**WELWYN HATFIELD BOROUGH COUNCIL  
ASSISTANT DIRECTOR (PLANNING)**

**Application No:** 6/2023/1574/FULL  
**Location:** 2 Mulberry Mead Hatfield AL10 9EN  
**Proposal:** Formation of a drop kerb to the rear of the site, with the addition of 3 parking bays to provide additional parking for a C2 Childcare home  
**Officer:** Ms Ashley Ransome

**Recommendation:** Refused

PROJECT STATUS	PRELIMINARY		
PROJECT	2 Mulberry Mead, Hatfield, AL10 9EN		
TITLE	BLOCK PLAN		
CLIENT	Lina Chirandura		
DRAWN BY	CHECKED BY	DATE	SCALE (@A1)
G.V.	Z.C.	28.07.2023	1 : 500
DRAWING NUMBER	UK2201-TD-A-002		
PROJECT NUMBER	BUILDING CLASS	PHASE	REVISION
UK23054

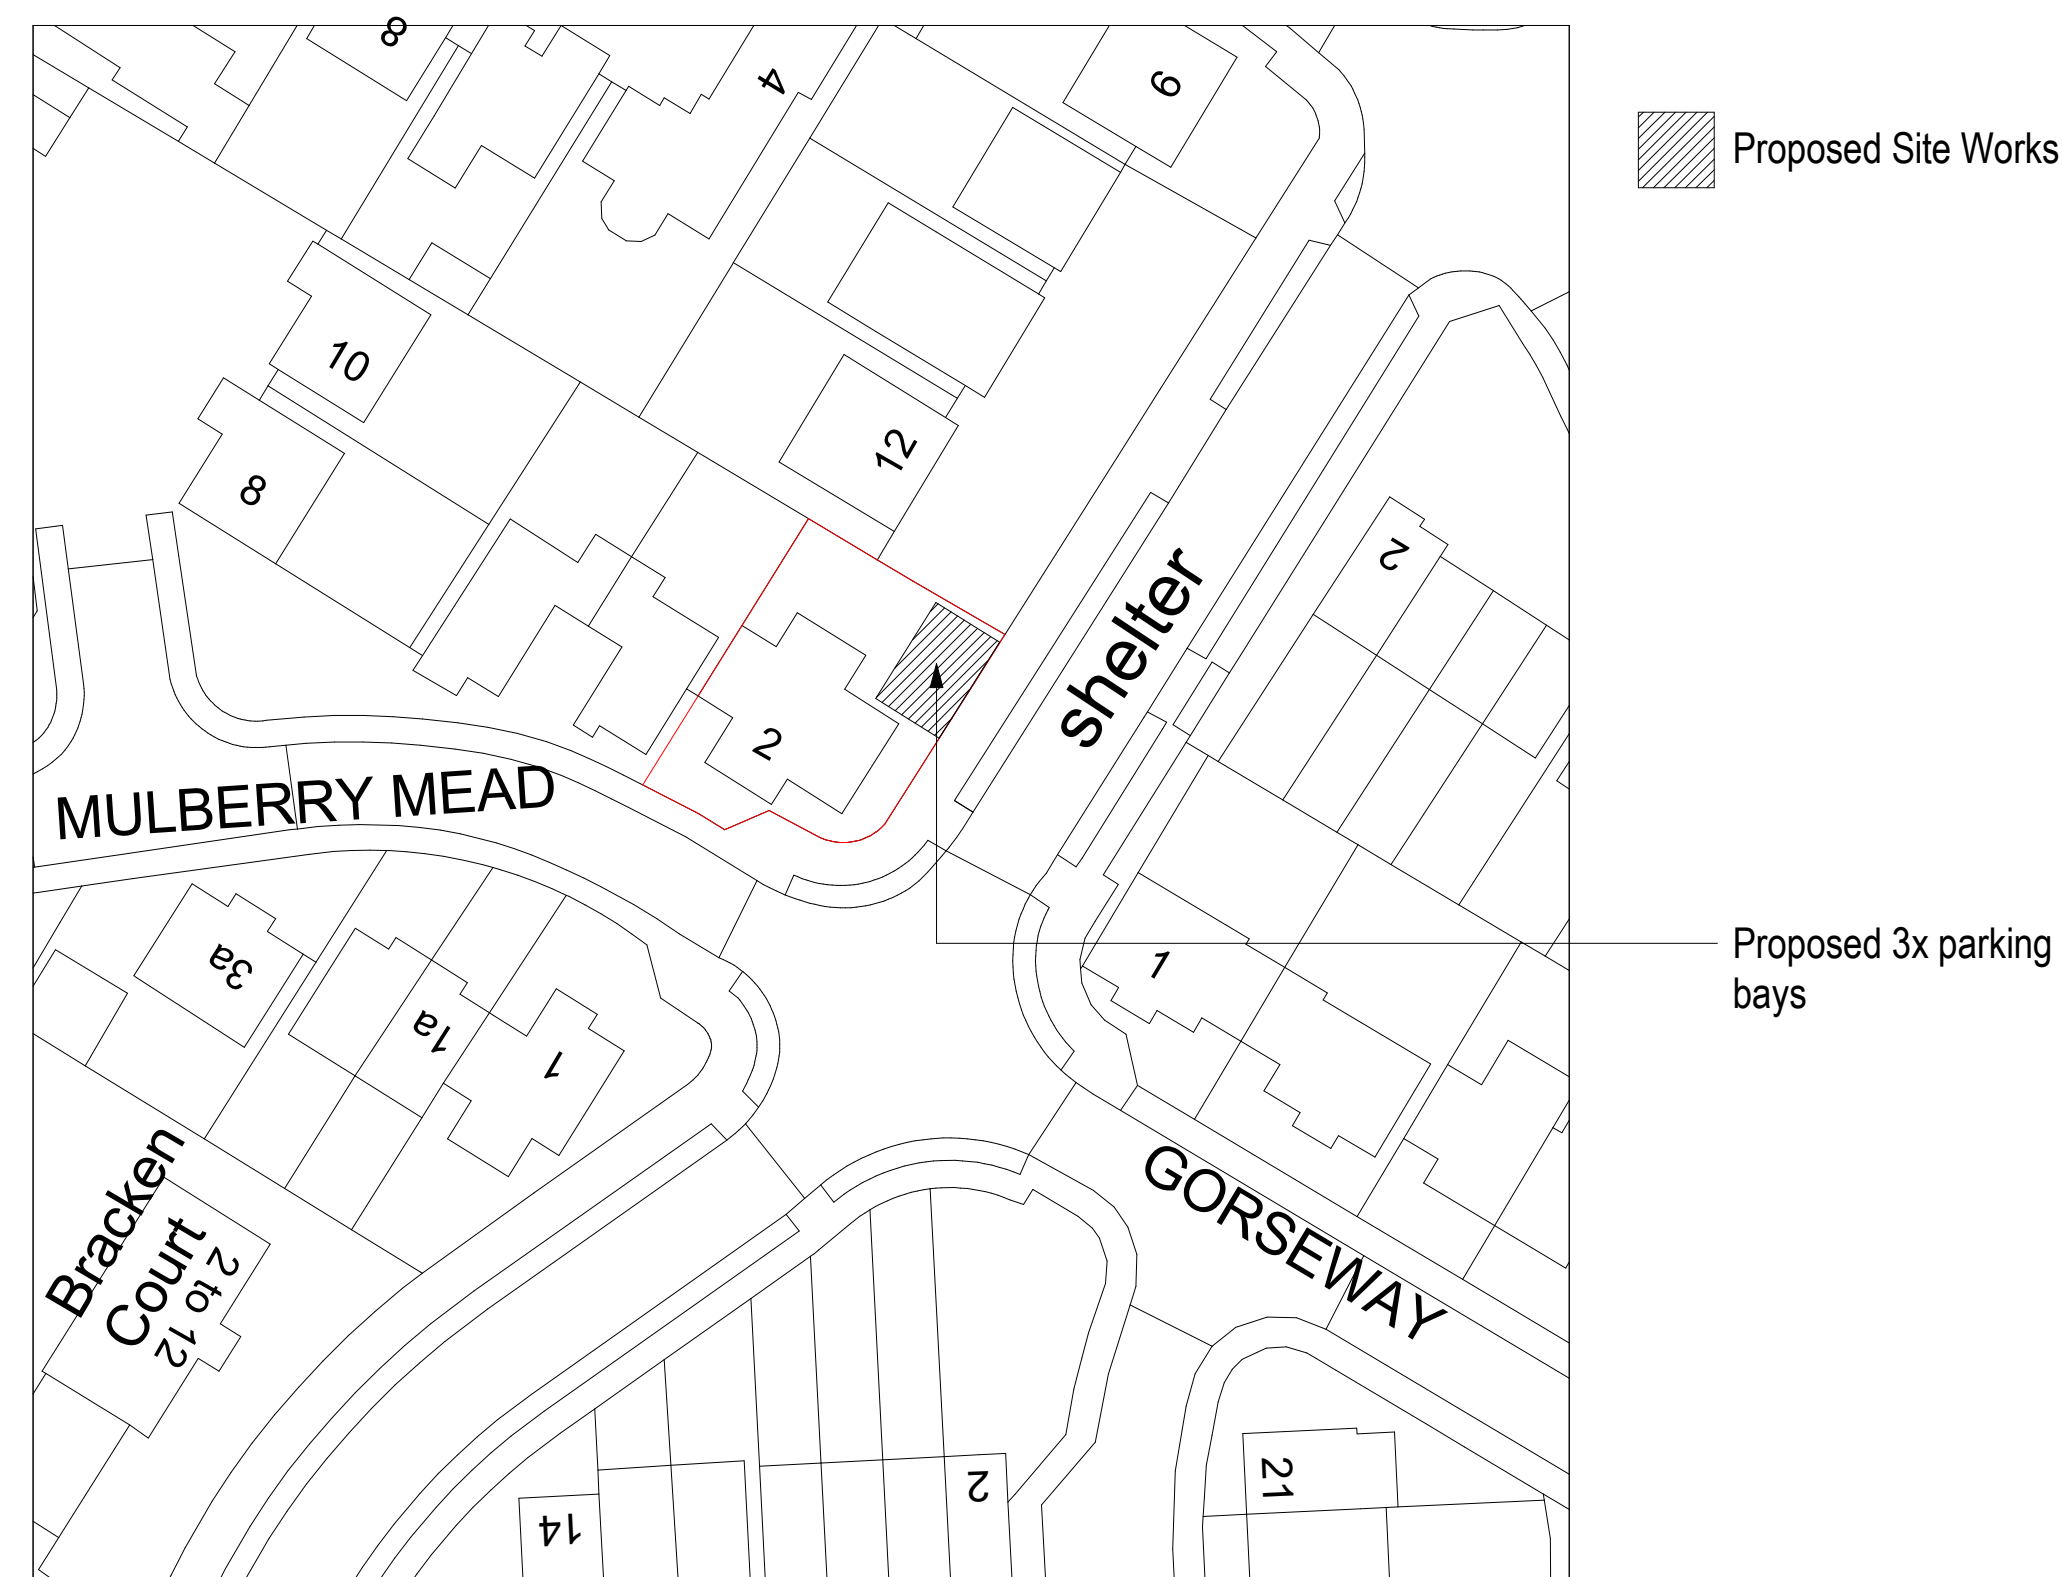
The site currently benefits from a single driveway and a single garage which is accessed from the front of the property from Mulberry Mead and accommodates two off street parking spaces. The proposal seeks to create an additional access to the side/rear of the site from Campion Road, and space for three further off-street parking spaces, thus totalling five off-street parking spaces. This would involve a change of use from amenity to residential land to allow the formation of a new access and area of crossover, in connection with the proposed creation of a driveway over the existing grass verge.

The existing grass verge along Campion Road presents a strong linear form, as does the existing mature boundary vegetation. Whilst it is acknowledged that crossovers do exist along Campion Road, they are few and far between, and generally serve as a shared access for a group of dwellings. In this regard, it is clear that the original planned layout sought to minimise the number of crossovers serving individual properties along Campion Road.

PROJECT STATUS	PRELIMINARY		
PROJECT	2 Mulberry Mead, Hatfield, AL10 9EN		
TITLE	PROPOSED PLANS		
CLIENT	Lina Chirandura		
DRAWN BY G.V.	CHECKED BY Z.C.	DATE 28.07.2023	SCALE (@A1) 1:50
DRAWING NUMBER	UK2201-TD-A-102		
PROJECT NUMBER	BUILDING CLASS	PHASE	REVISION
UK23054

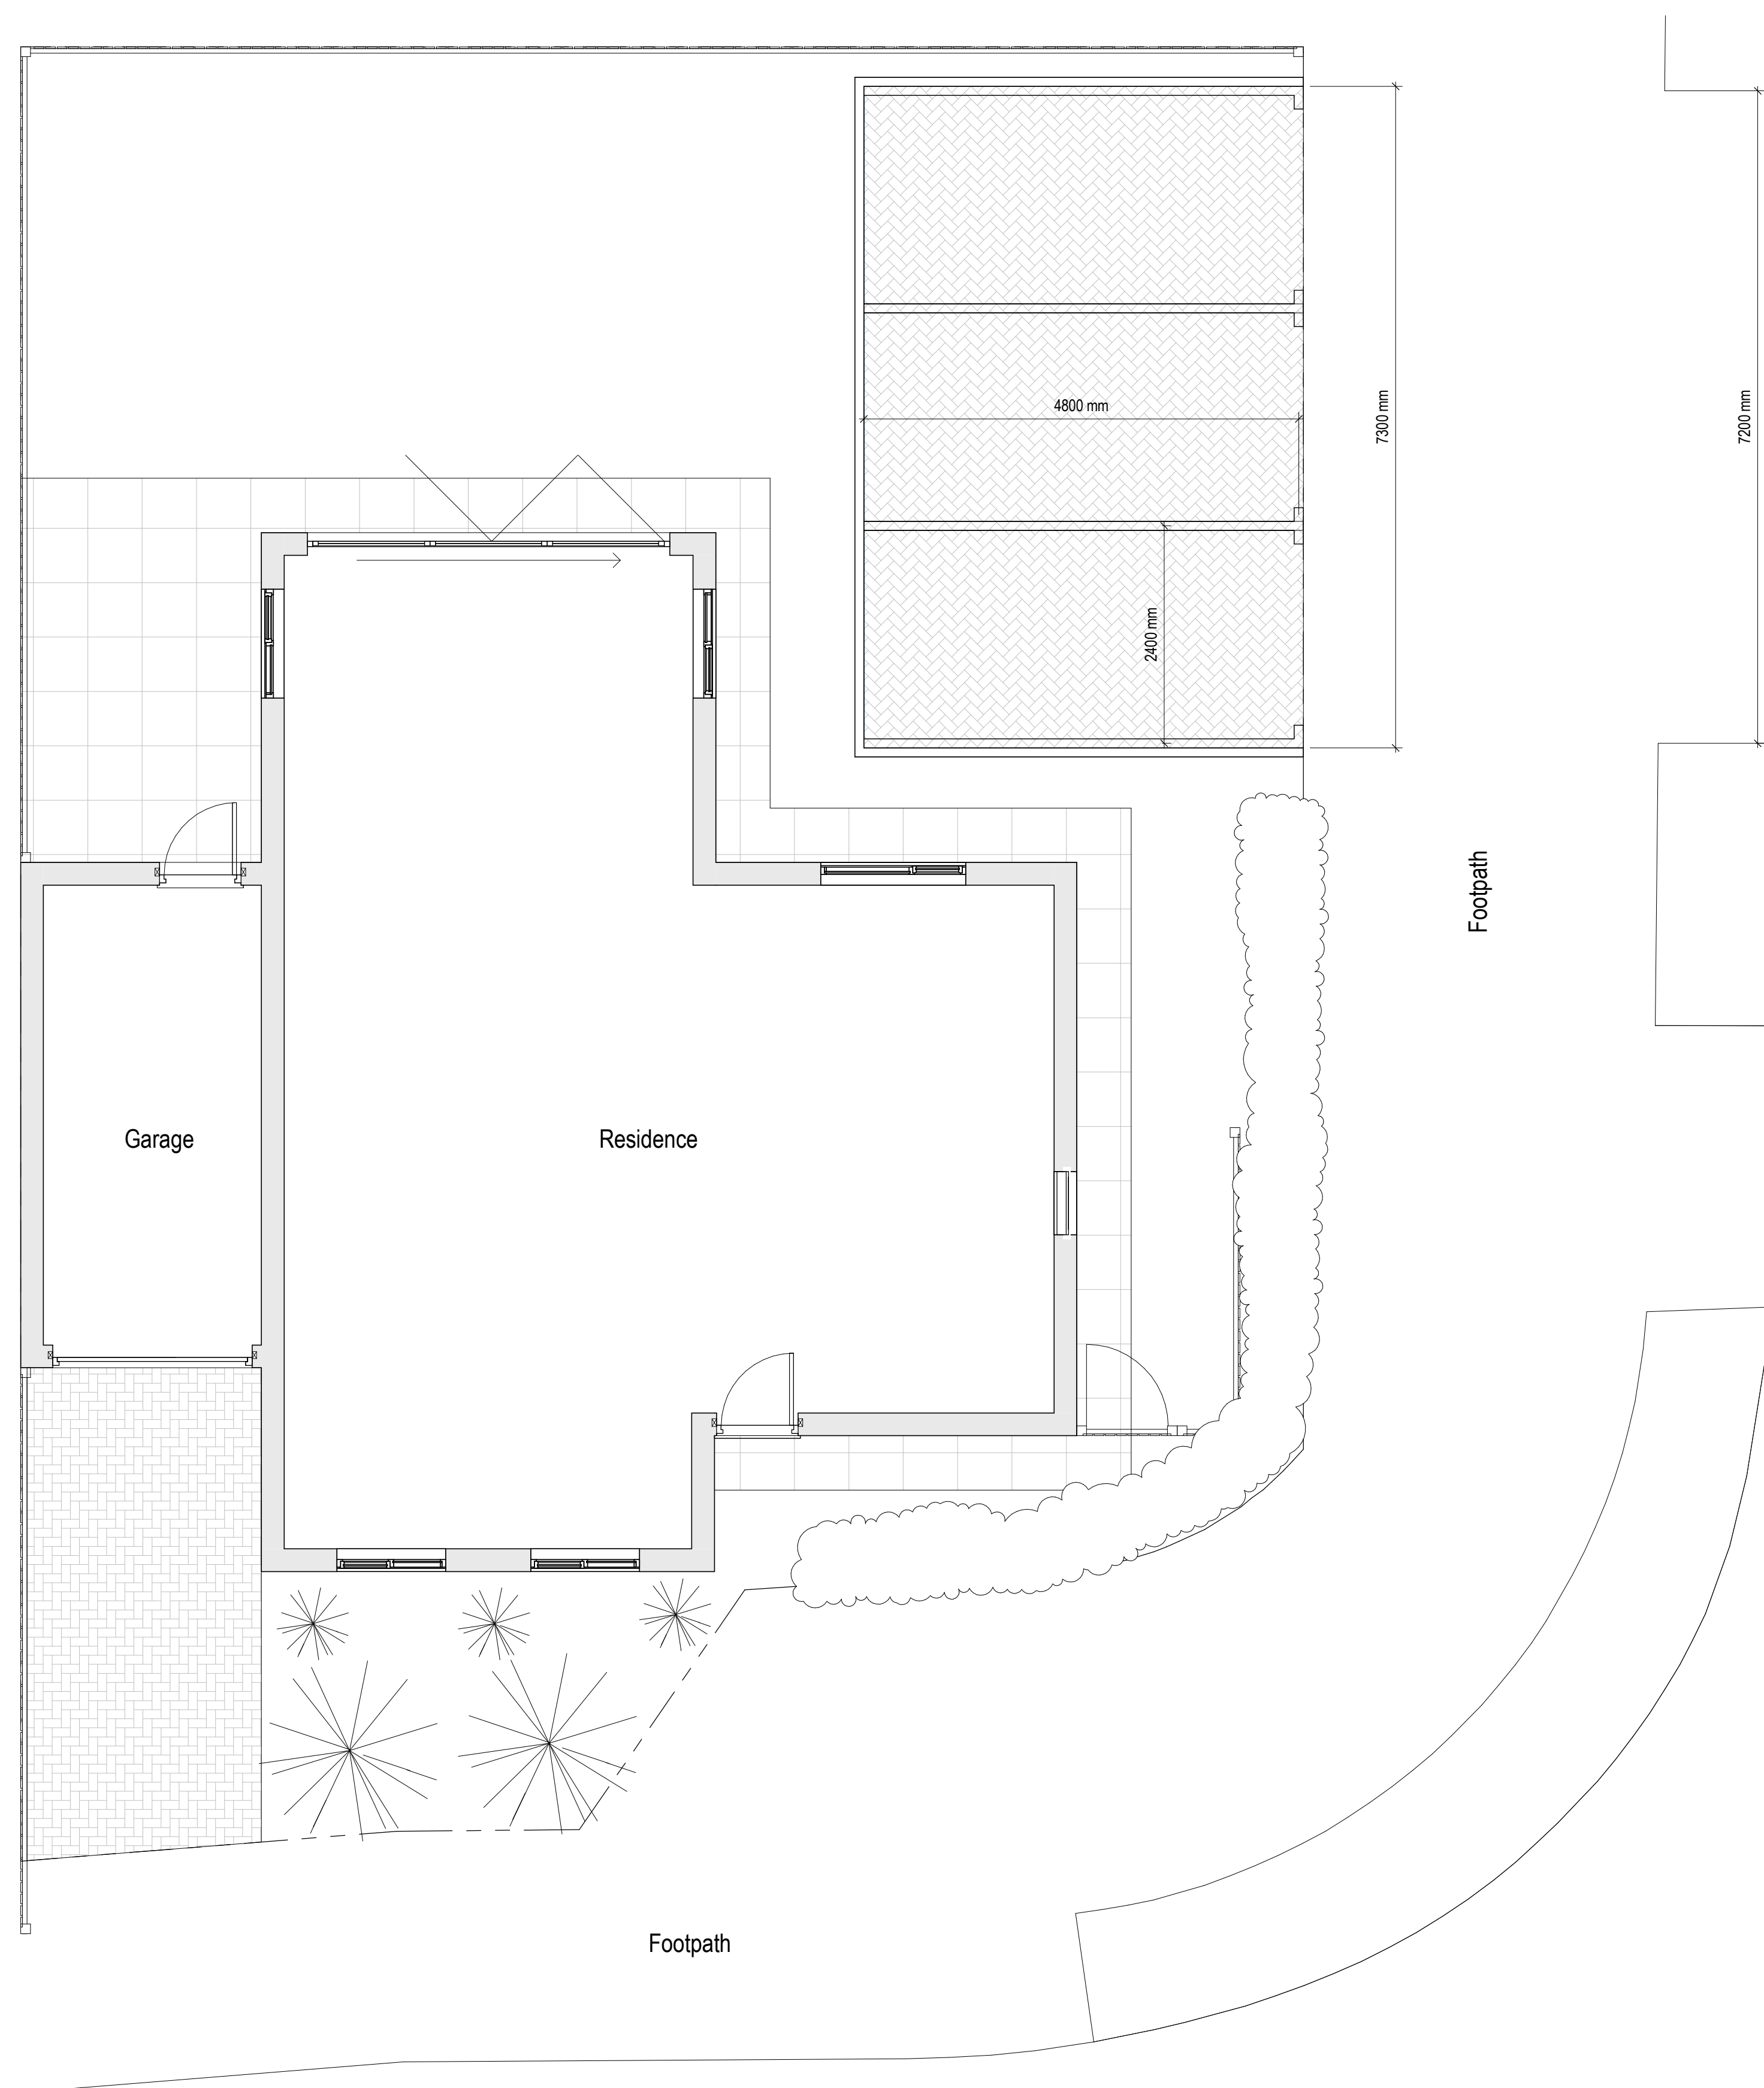
The plans detail that the proposed crossover would measure approximately 7.2 metres in width, enough for three cars to park side by side perpendicular to the highway. The vehicle hardstanding is proposed to occupy a large area of the existing rear garden, which on the submitted plan is detailed to span approximately 36 metres squared. No details of fencing or other means of enclosure have been provided, however, some form of enclosure would be necessary to secure the rear garden from the adjacent public highway.

The proposal would introduce hardstanding into the open grass verge, harming its function and resulting in a more fragmented appearance. The proposal would also remove a large section of the boundary vegetation to be replaced with a wide area of car parking. The application proposal fails to demonstrate any consideration to the inclusion of soft landscaping to mitigate the impact of the development. While landscaping and boundary treatment can often be secured by condition, this is not considered appropriate in this case as there is only very limited space surrounding the proposed parking area. As such, it would be impractical to provide planting along the northern boundary with No.12 Campion Road, and any meaningful landscape screening to the south and west of the parking area would obstruct two windows serving the application property whilst also encroaching further into the garden which would already be significantly encroached upon.

Whilst the surrounding character does include the presence of hard landscaping, this is however mixed with various forms of soft landscaping. In the instance of this application, the extent of hard standing is not balanced with some form of soft landscaping to positively impact upon the character of the street. Furthermore, the likely need for fencing to be erected around the proposed parking area to enclose the altered garden area would further the impact upon the character, posing a cramped form of development.

<p><b>Any other considerations</b></p>	<p>In addition to the above, the application indicates that the proposal would remove the existing side boundary fence to make way for the proposed parking area. However, no details of how the site would be secured, following the addition of the parking area, have been provided. From the plans, it appears that there would be no boundary fence to enclose the site, and as such, this would represent a safety concern to the occupants of the C2 children's home.</p>
